**Town and Country Planning Act 1990  
Application for Permission to Develop Land**

**Response from Pollution & Noise Control**

<b>PNC Reference No:</b>	WK/201721918
<b>Name of Planning Officer dealing with the matter:</b>	Nick Hirst
<b>Application Number:</b>	2017/93396
<b>Proposed Development:</b>	Demolition of existing industrial buildings and erection of 18 apartments with associated landscaping works to form vehicular parking, cycle parking and refuse storage areas (within a Conservation Area)
<b>Location:</b>	Vale Works, 25 Morley Lane, Milnsbridge, Huddersfield, HD3 4NS
<b>Date Required By Planning:</b>	08/11/2017

**DRAWING TITLE:** PROPOSED DRAWINGS  
SITE LAYOUT PLAN

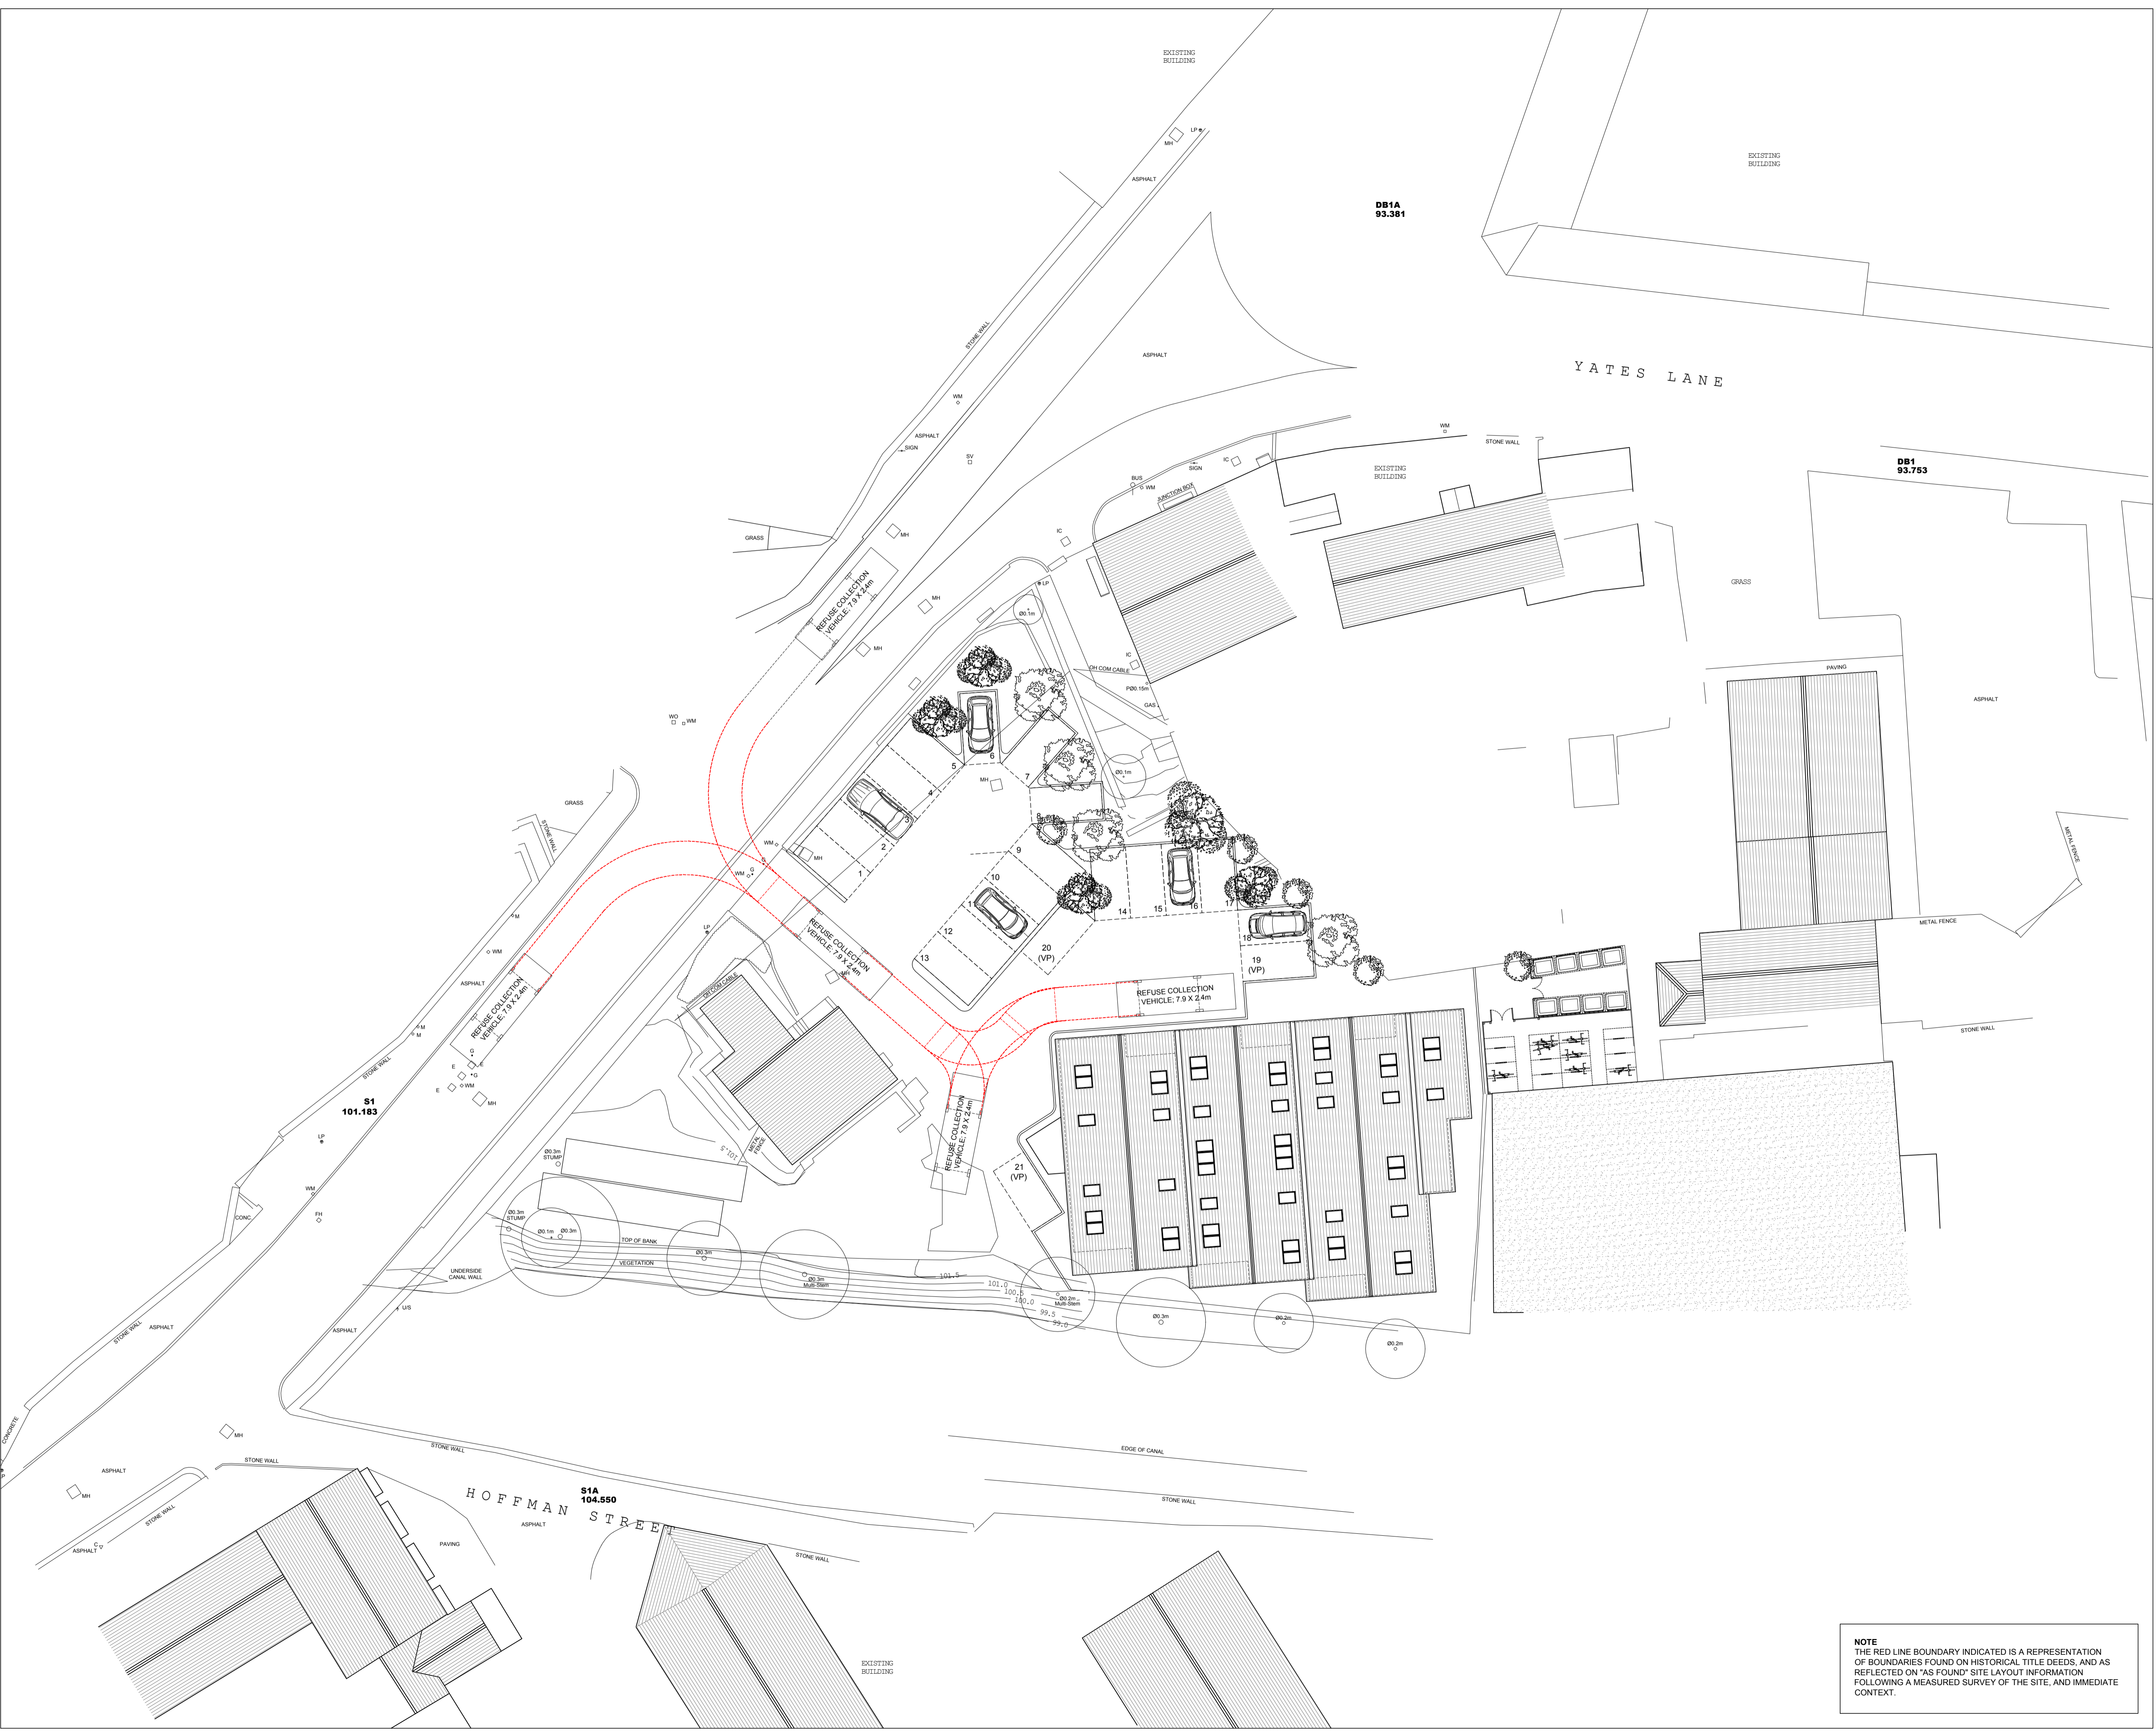
This development has been assessed in accordance with the West Yorkshire Low Emission Strategy Planning Guidance. The size of the development is less than that of prescribed values set out in this document, which is why it is regarded as a minor development.

We therefore require the following condition:

Install 1 charging point per unit (dwelling with dedicated parking) or 1 charging point per 10 spaces (unallocated parking).
